**Our Ref: FP/194/12/
Your Ref:**

**Town & Country Planning Act 1990 (as amended)
Town and Country Planning (Development Management Procedure) (England) Order 2010 (as amended)
Application for Planning Permission**

Development Change of use from office (A2 Financial & Professional Services) to residential (C3 Dwelling Houses)
Location 119 Felpham Way Felpham

Site and Block Plan

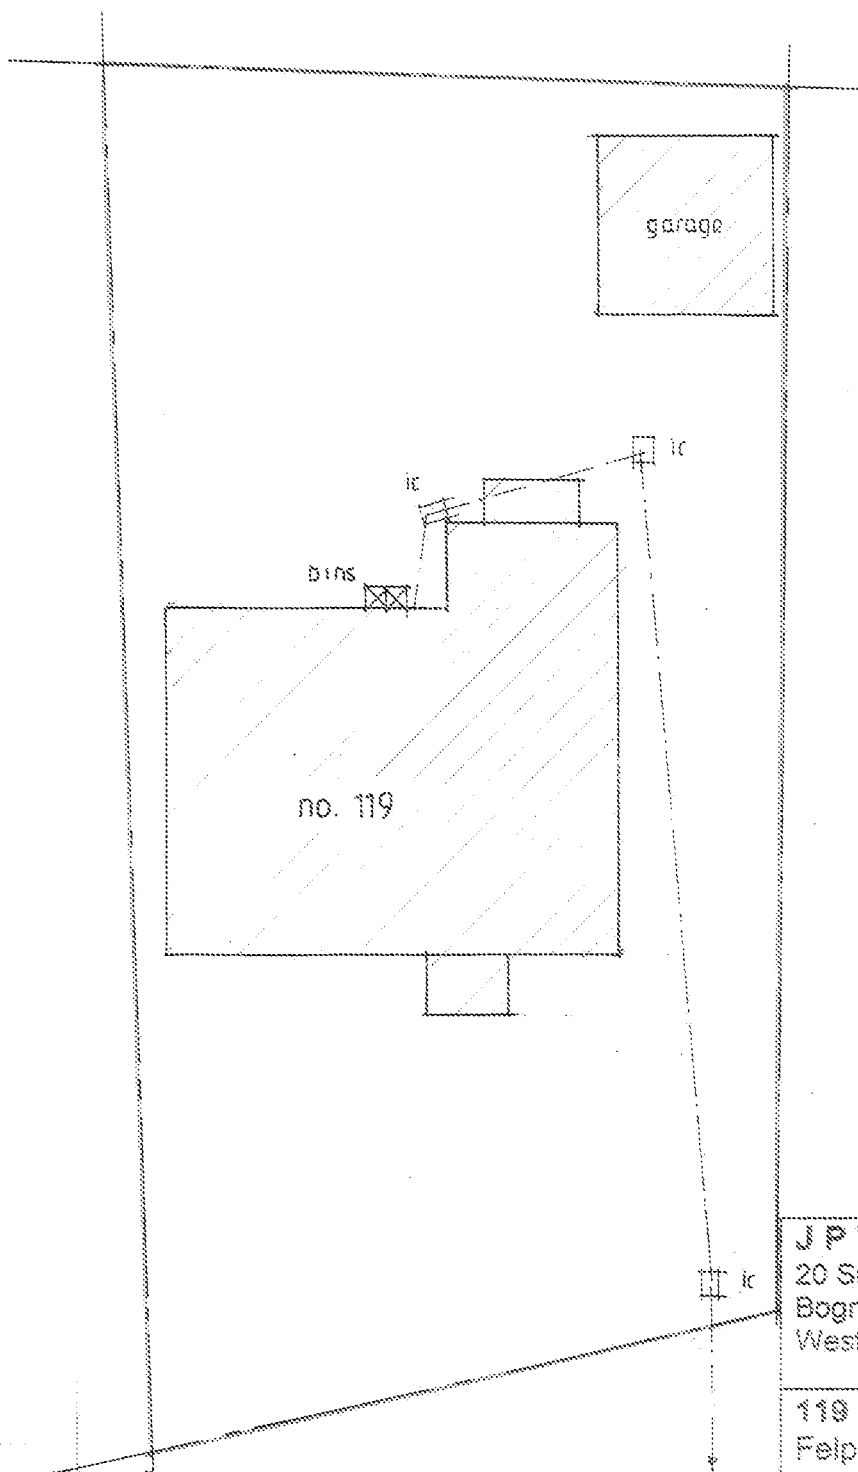
Please submit 1 electronic or 3 paper copies of a block/site plan in accordance with the guidance notes available on our website detailed below (click on National List). Please show the position of the rubbish/recycling area.

**Existing & Proposed
Elevations.**

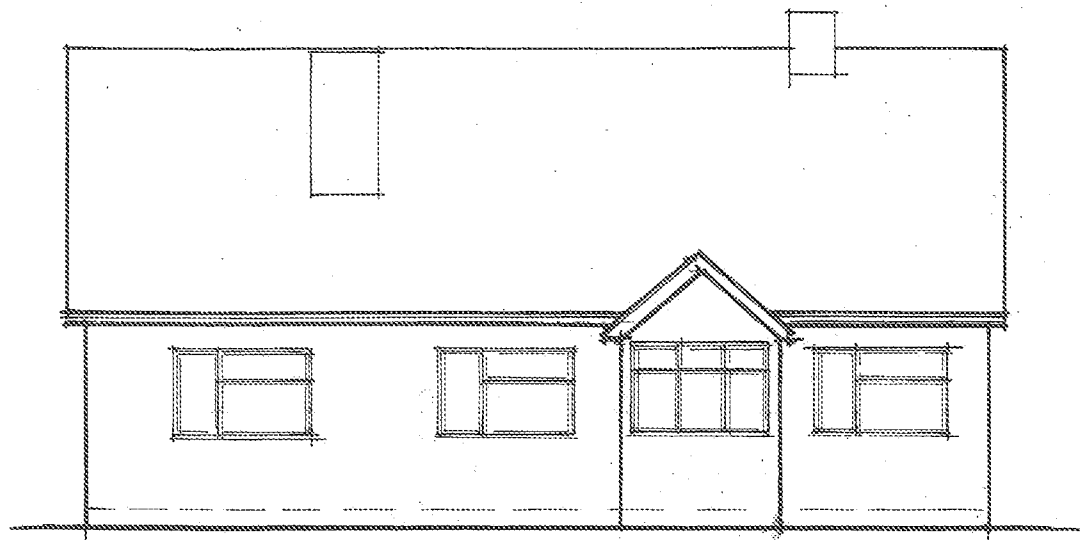
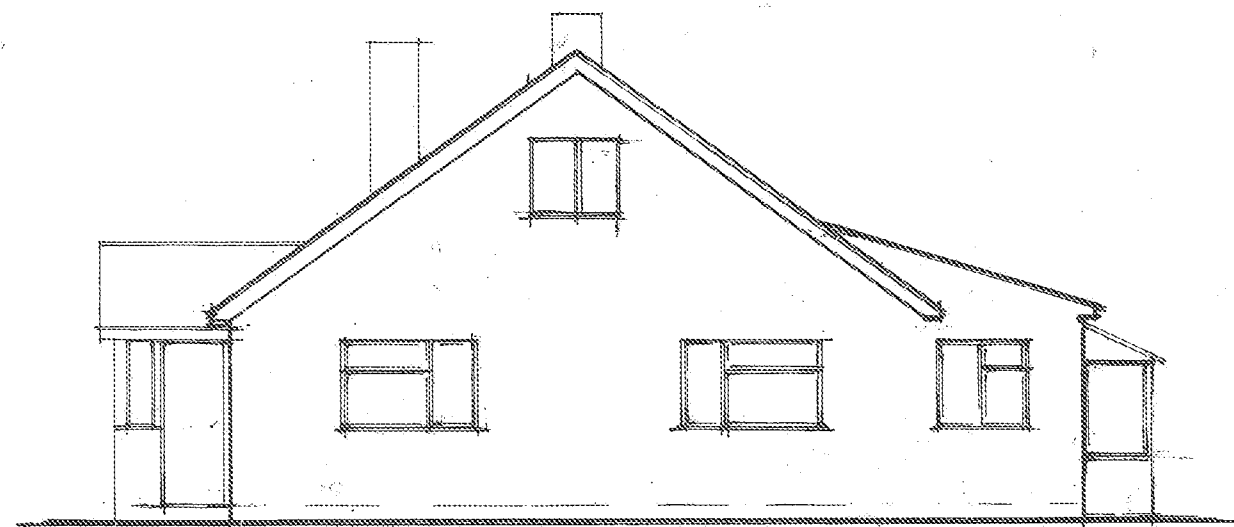
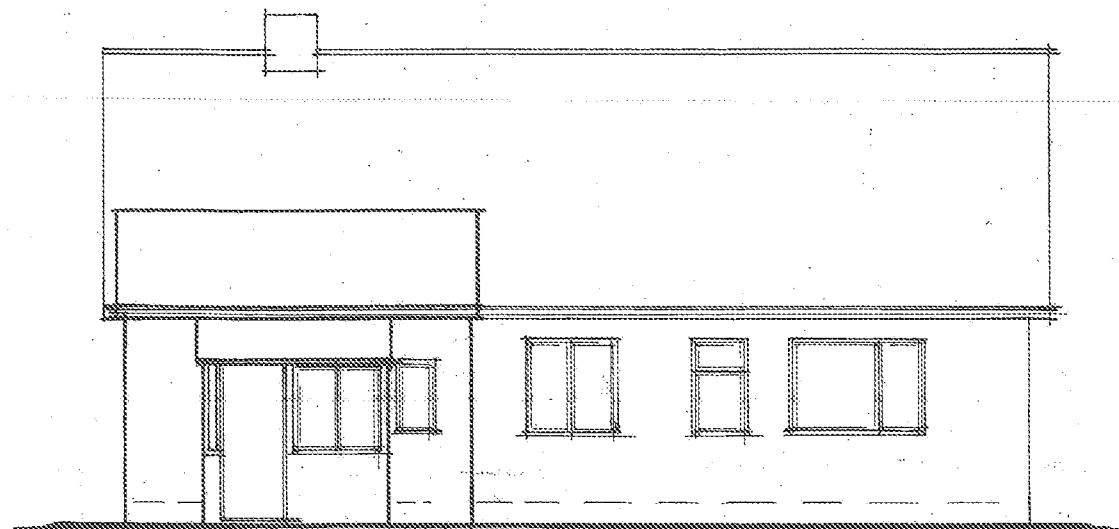
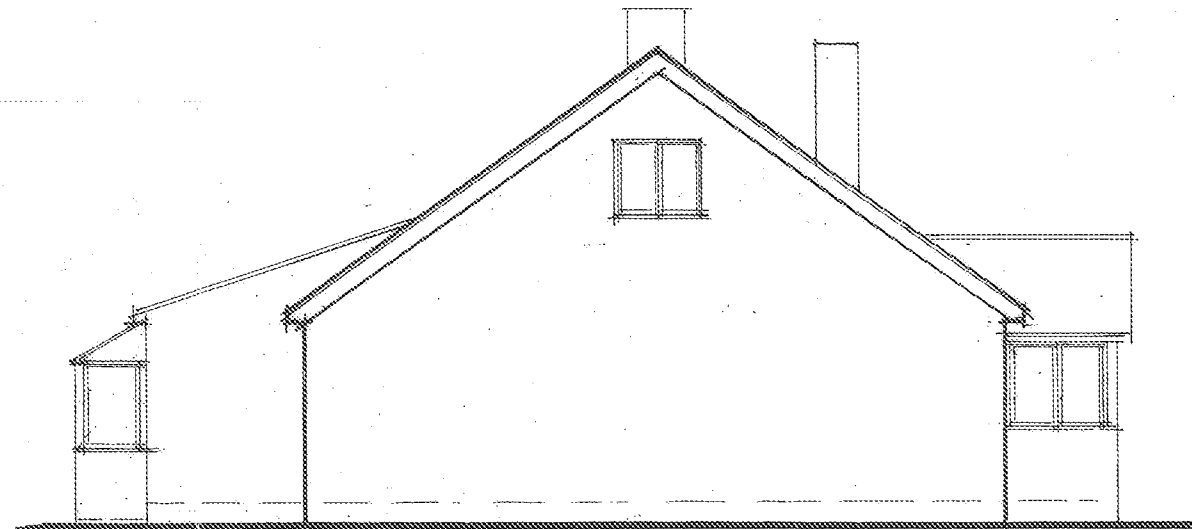
Please submit 1 electronic or 3 paper copies of existing and proposed elevations in accordance with the guidance notes available on our website detailed below (click on National List). You may send a plan with the elevations on it and label it 'Existing and Proposed Elevations'.
